Munmorah Power Station
Rehabilitation

Submissions Report

Submission date
December 2009

Pollutant contours – SO₂, NO₂ and PM₁₀

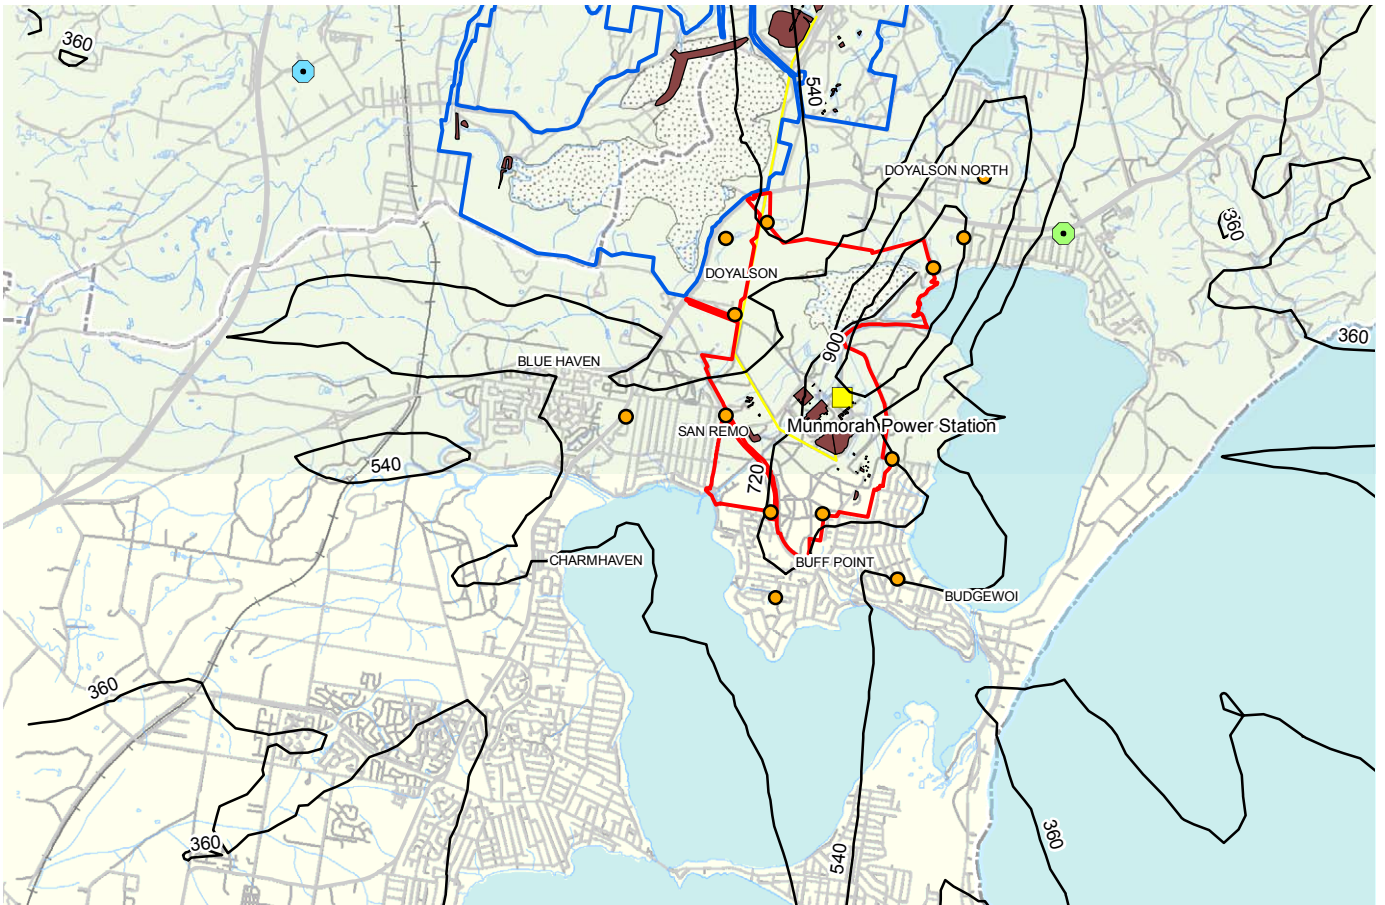
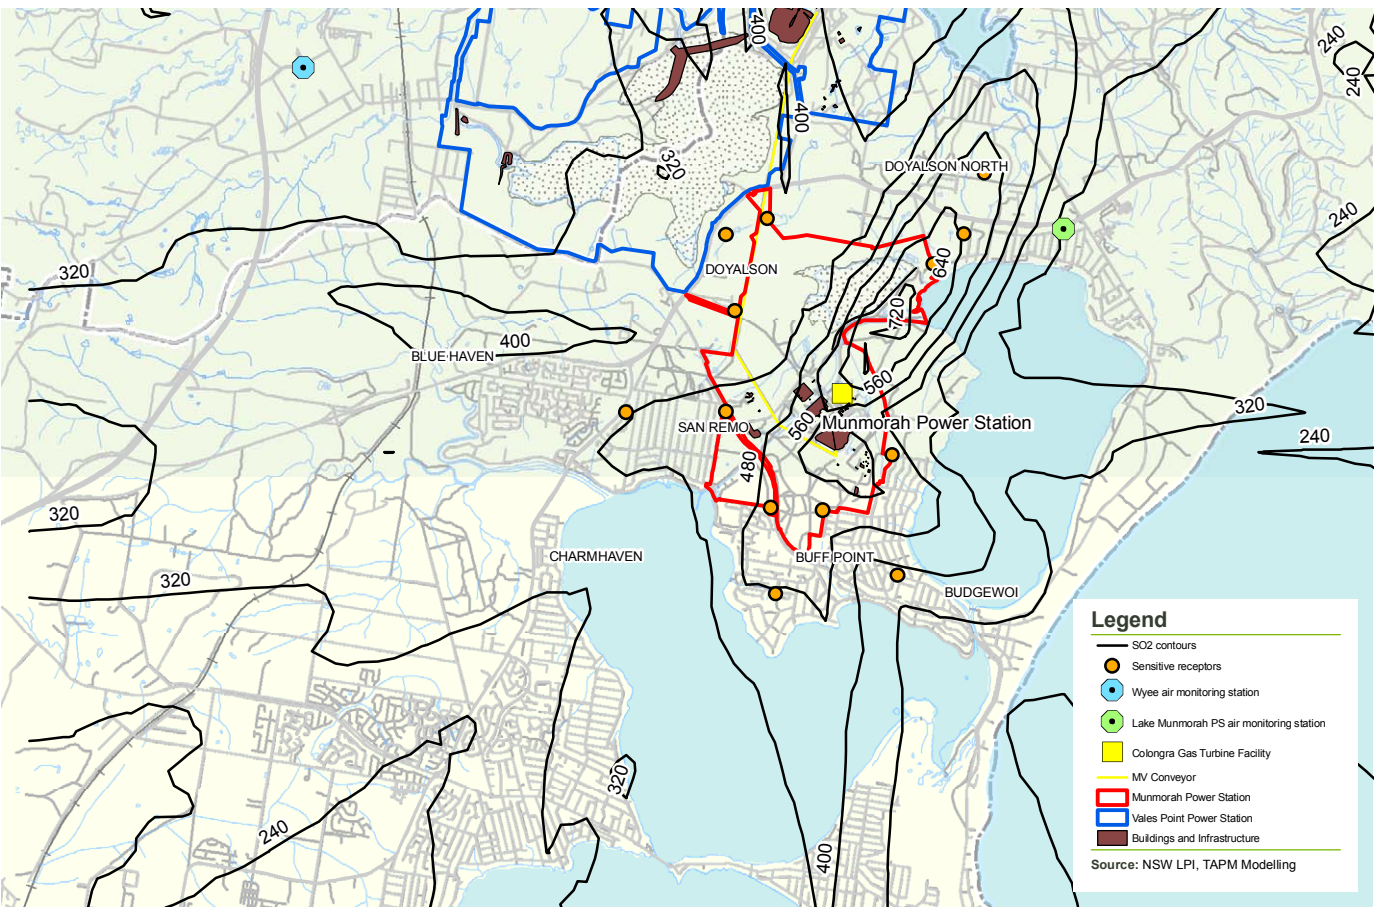
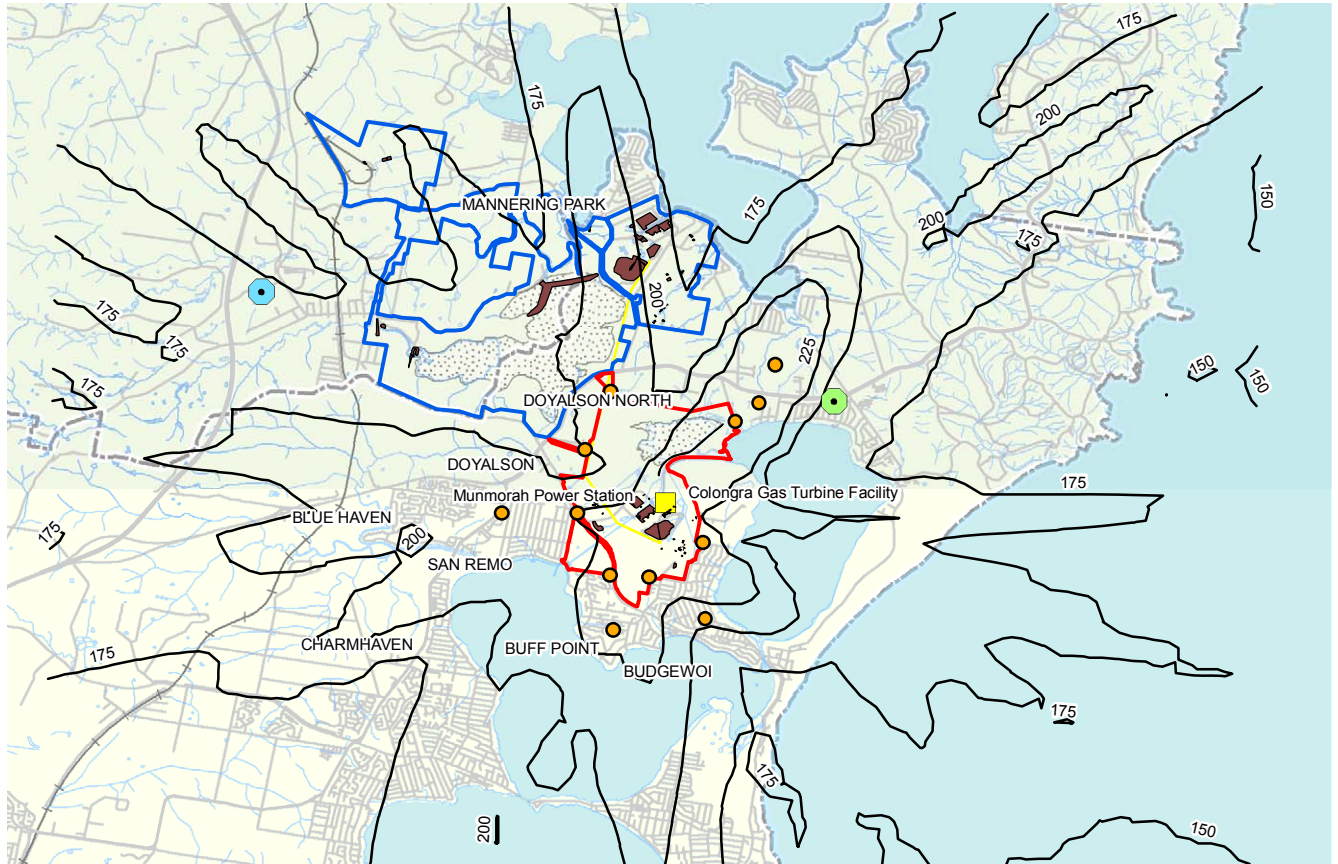
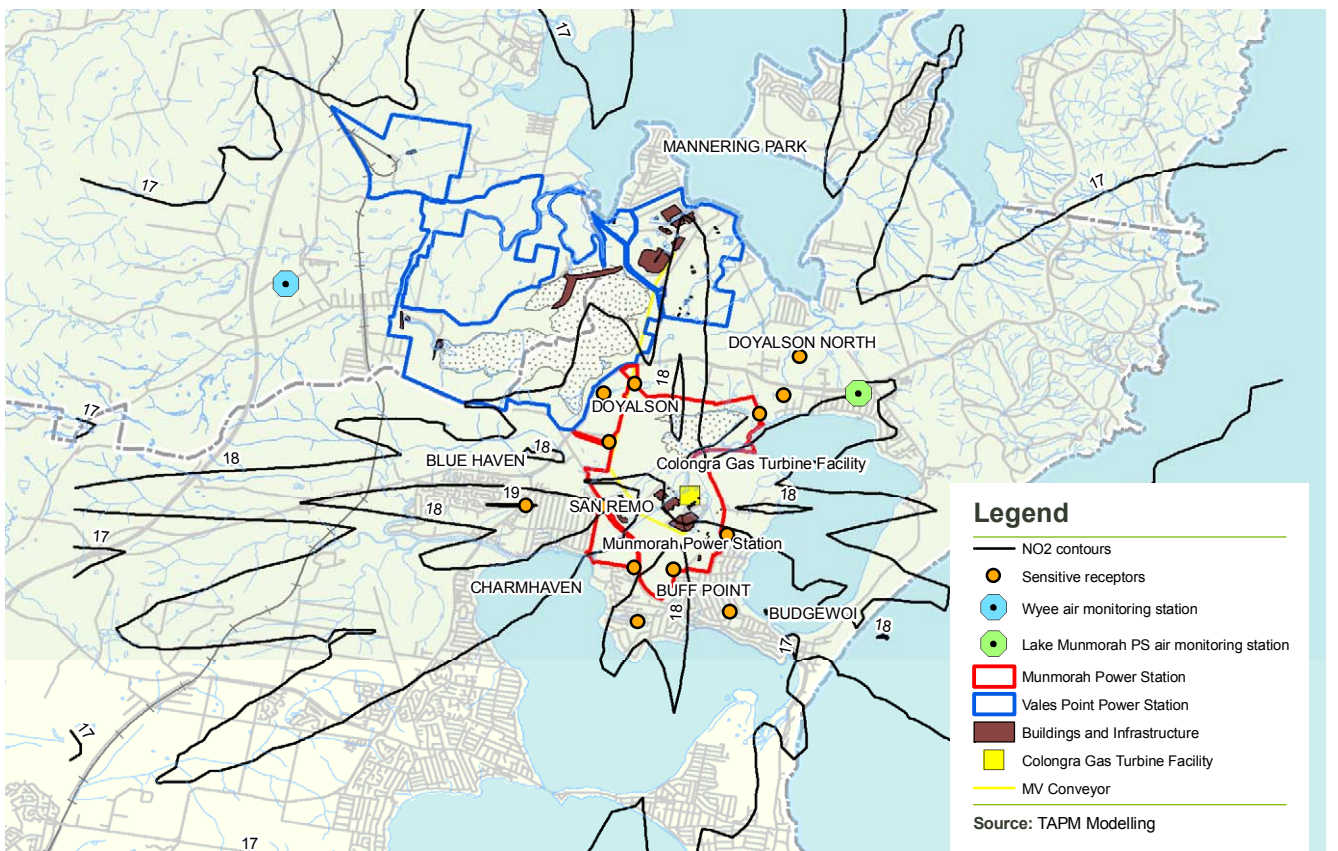
Attachment B of Appendix E presents contour (isopleth) plots for the assessment. The NO₂ and SO₂ contour plots are not appropriate for the various reasons.

The contour plots have been reviewed and corrected where necessary. The isopleths are presented in Appendix C of the updated air quality assessment provided as Attachment B to this report
